STATE OF NORTH CAROLINA
DEPARTMENT OF TRANSPORTATION

Addendum No. 1

RE: Contract ID: C201118
WBS # 34467.3.8
Proposal No. 2
Bladen County (R-2562D)
NC-87 From SR-1191 (Old NC-41)
To NC-41 and NC-87 Business.

TIP NO. R-2562D	SHEET NO. SIGN-4
--------------------	---------------------

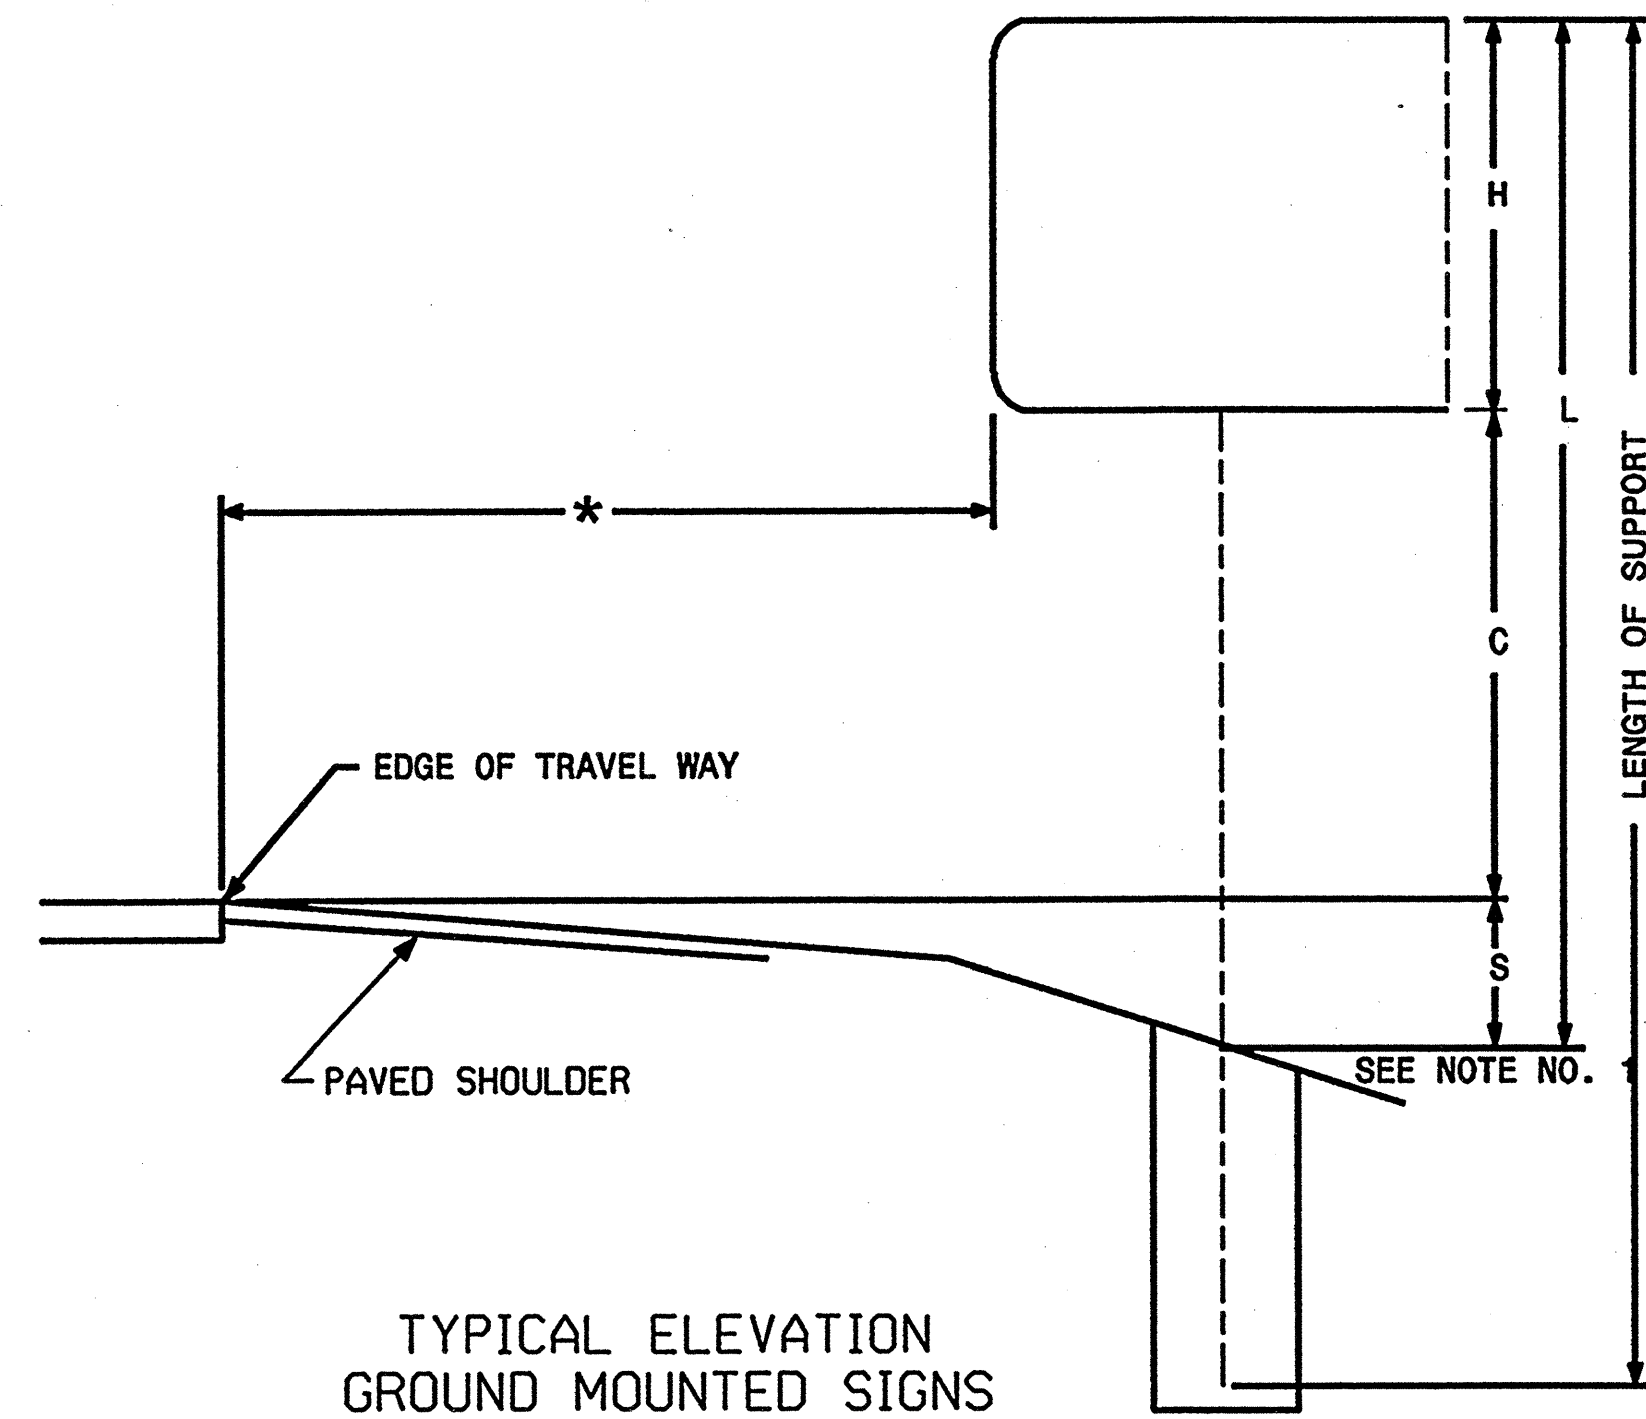
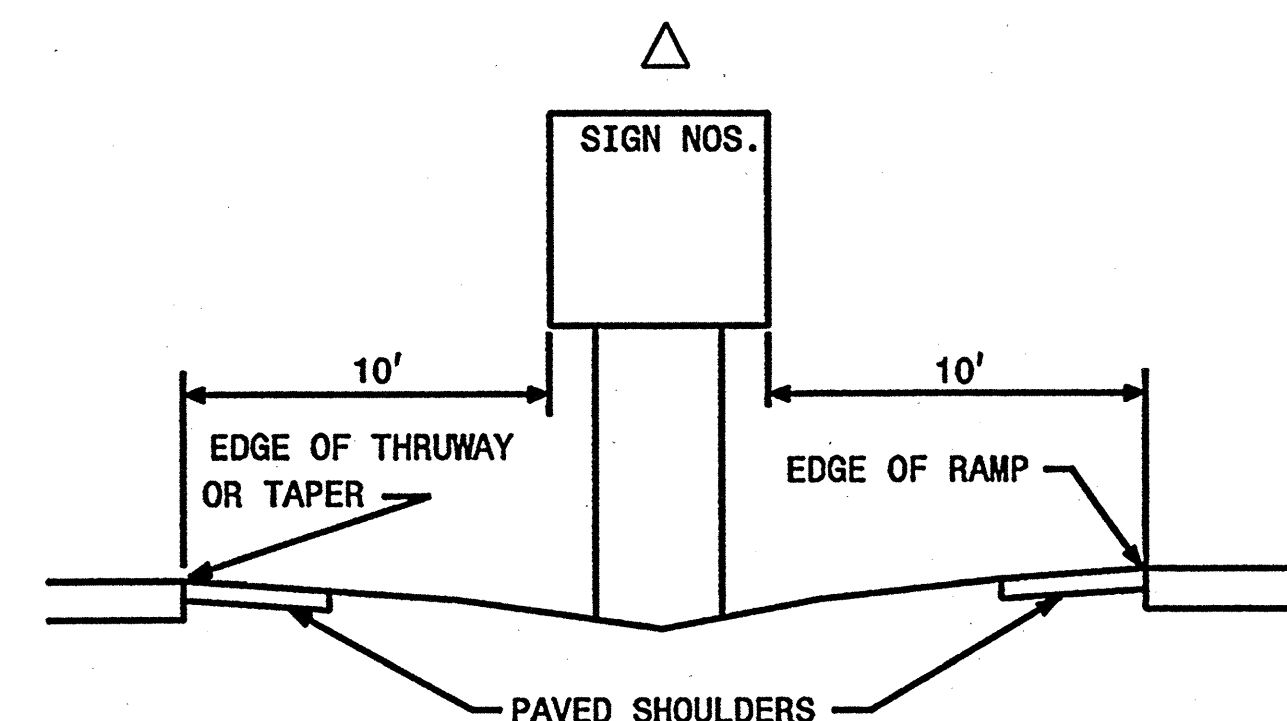
<u>Sheet No.</u>	<u>Revision</u>
2-F	Revised ditch detail stations for Detail "A"
3-L, 3-M	Revised quantity of 375 MM RC Pipe
3-R, 9 and 10	Revised Right of Way
10 and 36	Removed ditch, revised drainage system and added median ditch from-Lrev-Sta. 27 + 40 to 27 + 60
SIGN-4	Added Sign Support Data
X-55	Added Median Ditch
